Aquind Interconnector

Written Representation

October 2020

1.1 The South Downs National Park Authority (SDNPA) objects to the proposal for the development of a Converter Station in close proximity to the National Park and the associated Development Consent Order (DCO) application on two grounds:

Plate 3.8 - Converter Station Parameter Plans (two options, Option B(i) Blue dash and Option B(ii) Green dash)

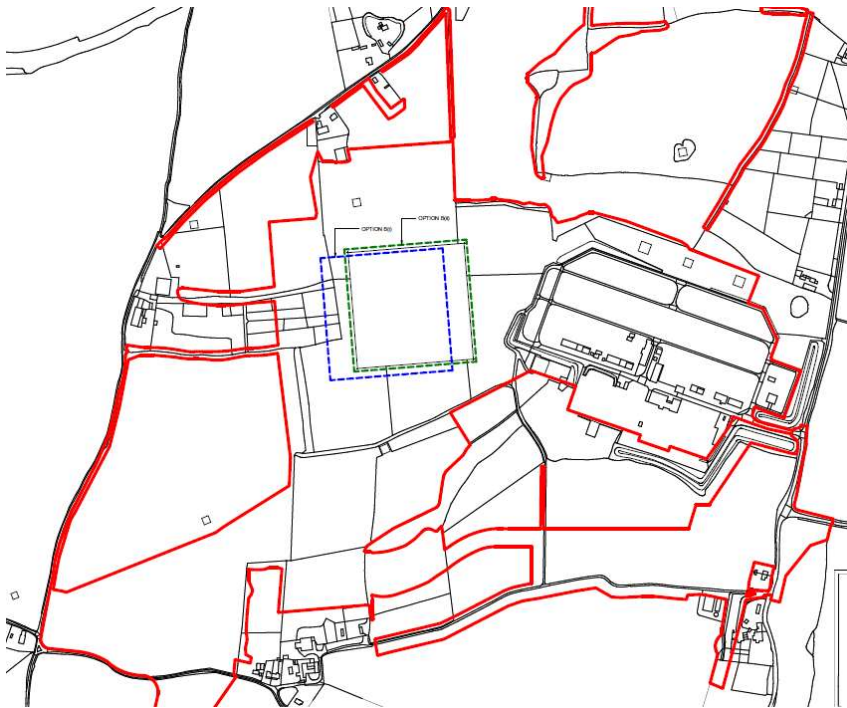
- 4.11 A summary of SDNPA’s concerns in respect of landscape and visual impact is as follows:
- i) The adverse impact from siting buildings of the large size and scale proposed so close to the National Park (within the National Park’s setting). The proposed Converter station buildings are significant both in terms of footprint and height.

- 4.16 The proposed Converter Station development is significant both in term of its footprint and height. The extent of this is immediately apparent in the wireframe photomontages particularly from within, and on, the boundary of the SDNP. There are no comparable built forms within the landscape at this elevation on the Downland Mosaic Landscape Character Area and the buildings would appear alien and overdominant.
- 4.17 The buildings would have a functional and utilitarian appearance which will be very prominent and, although close to the existing substation, will not be seen against a

- v) There is a large amount of landform change to achieve the building platform, for the Converter Station buildings which is set at 85m – this means that the platform is half cut (north) and half fill (south). It is unfortunate that the building could not be set lower in the landscape to help ameliorate the extensive height of the building.

Drawing file: EN020022 / EN020022-000735-6.2.15.49 ES - Vol 2 - Figure 15.49 Indicative Landscape Mitigation Plan Option B(i) (south).pdf

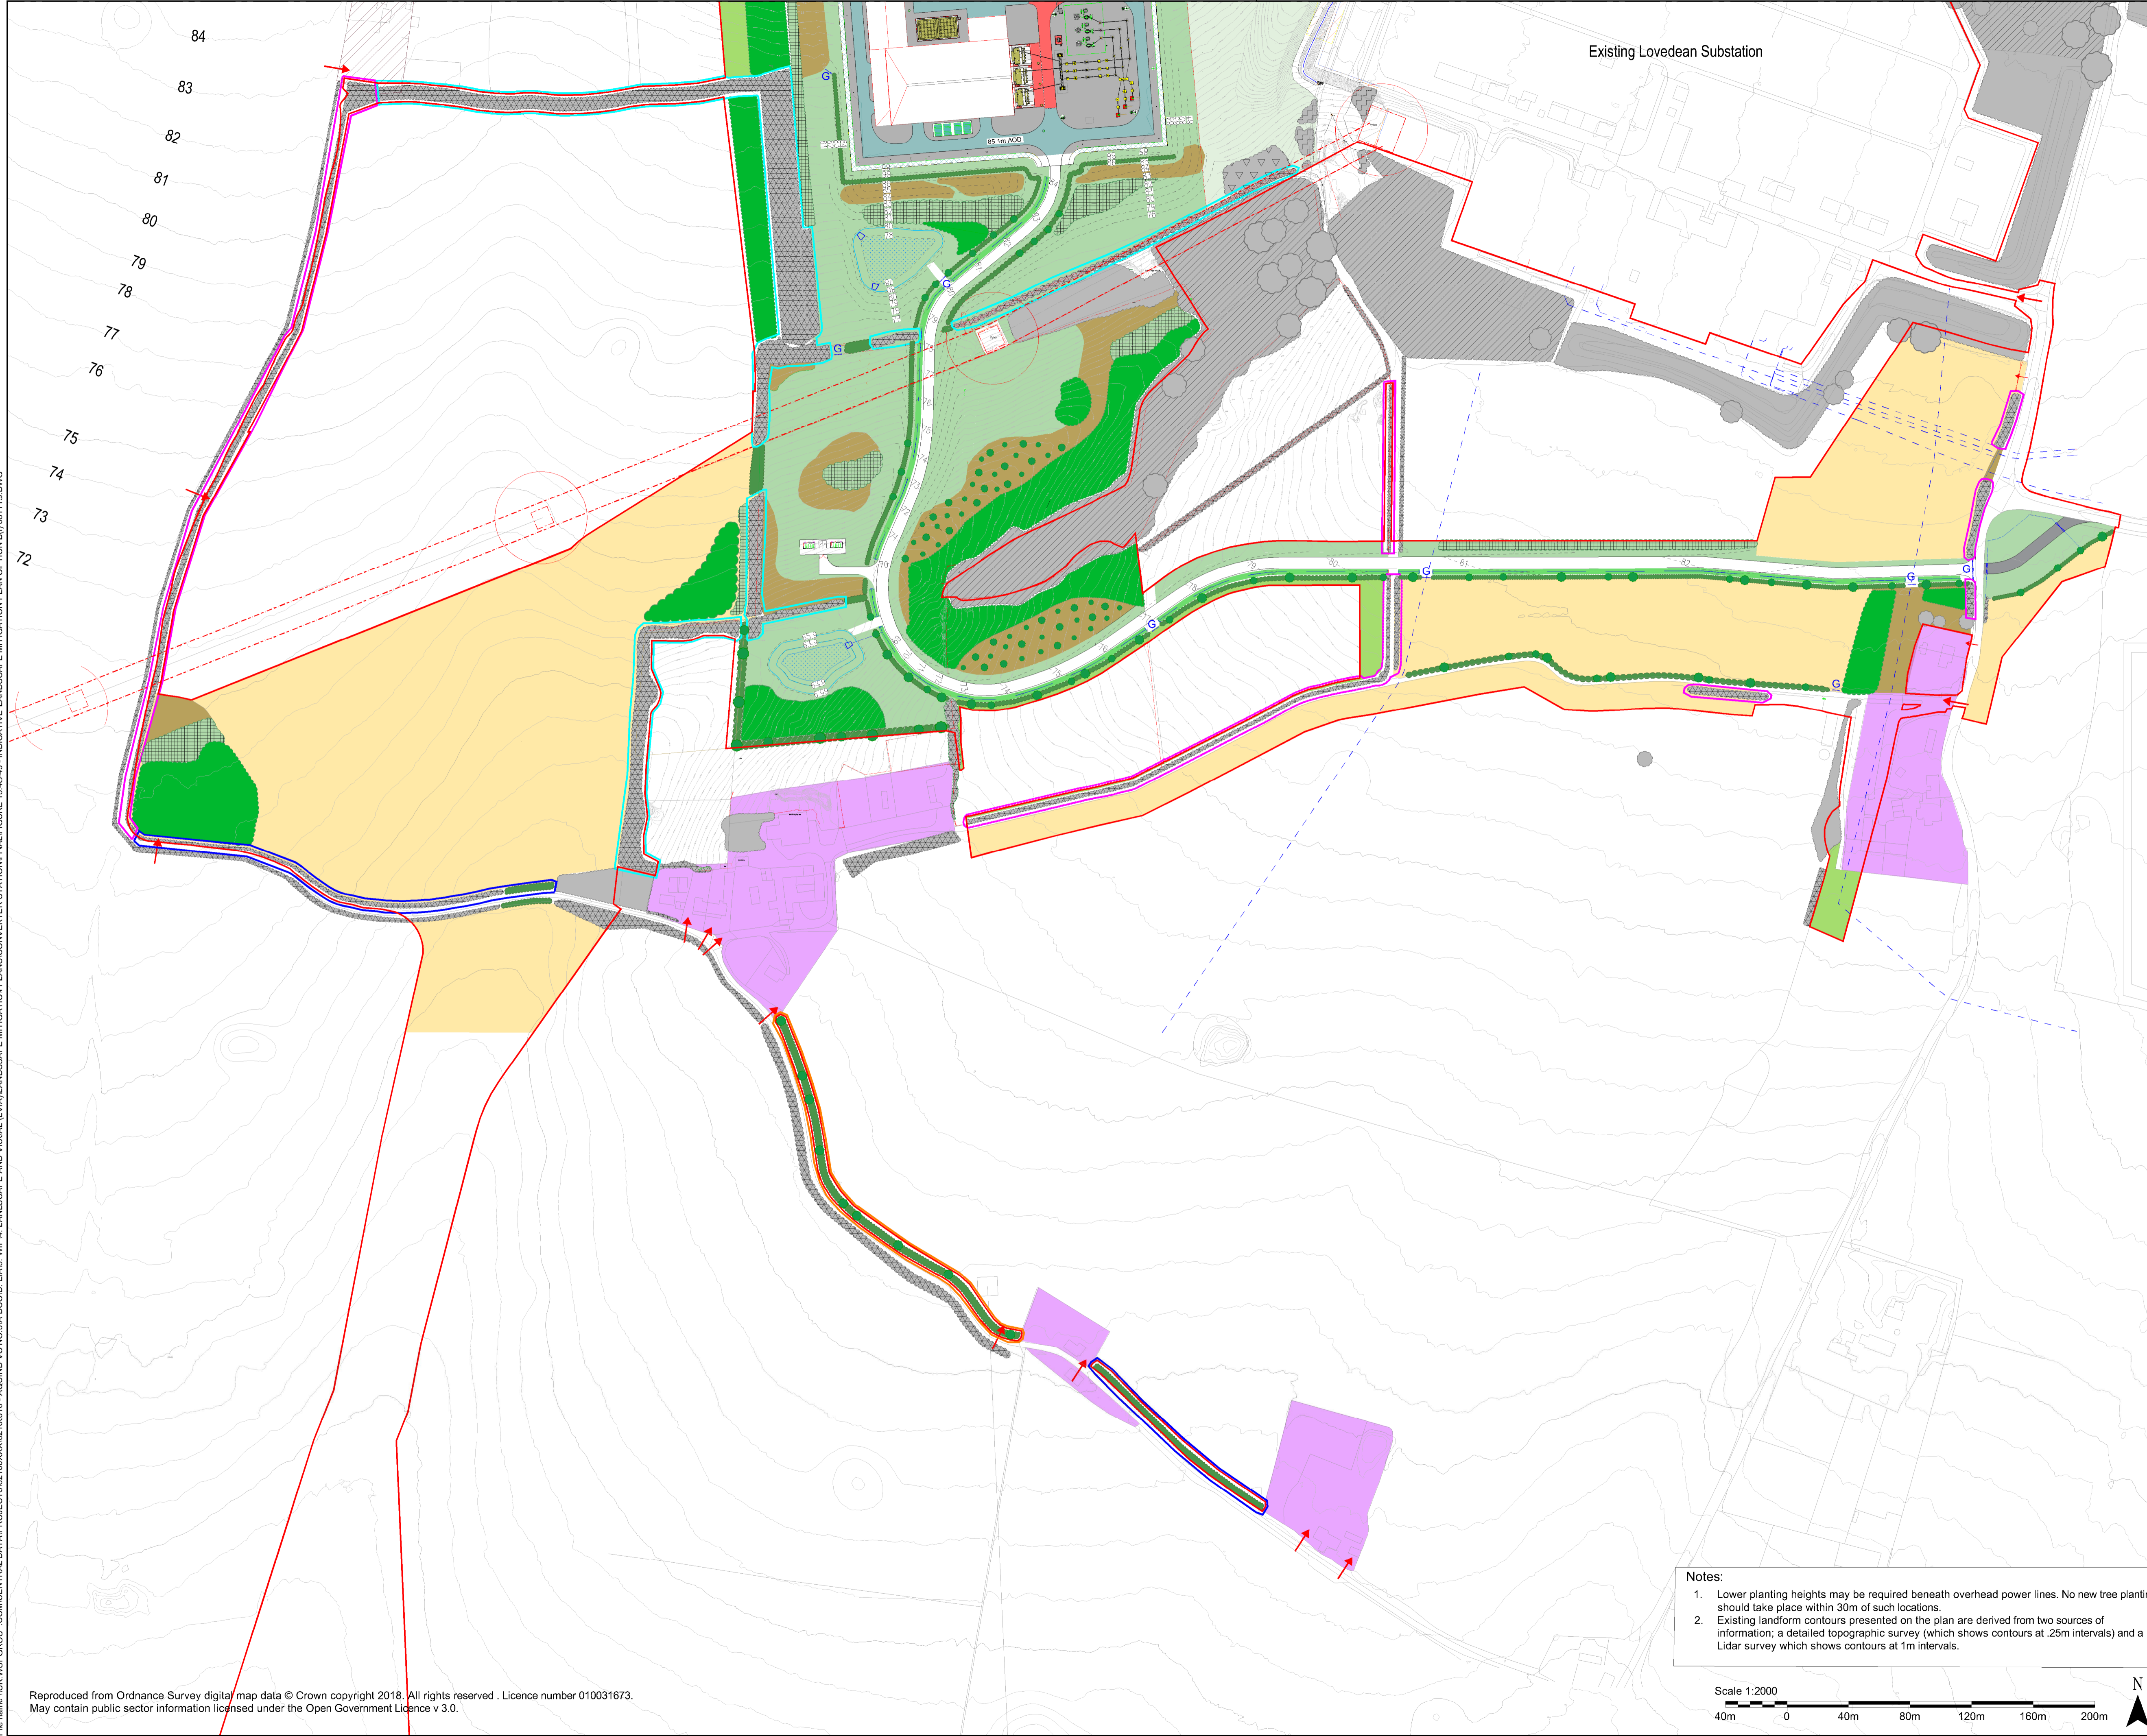
- 4.25 The SDNPA wish to make the following points on this matter:
- iv) It would be helpful if the colour selected for the Converter Station buildings were more recessive and also responded to the height of the building by perhaps greying out colours towards its top. The building is viewed from all sides and this makes it problematic to select one colour swatch for all sides. It is suggested that the approach is developed with more nuance and relation to the direction of sunlight, shadow, backdrop, skyline and view orientation. Each side of the building may need a different colour approach in order to successfully integrate it into the landscape.

- vi) The landscape mitigation proposals are relatively complicated and we would suggest that additional new woodland planting is proposed. For example, whilst the limitations on woodland planting along the perimeter security fence are acknowledged, this does not preclude more significant woodland planting further away.
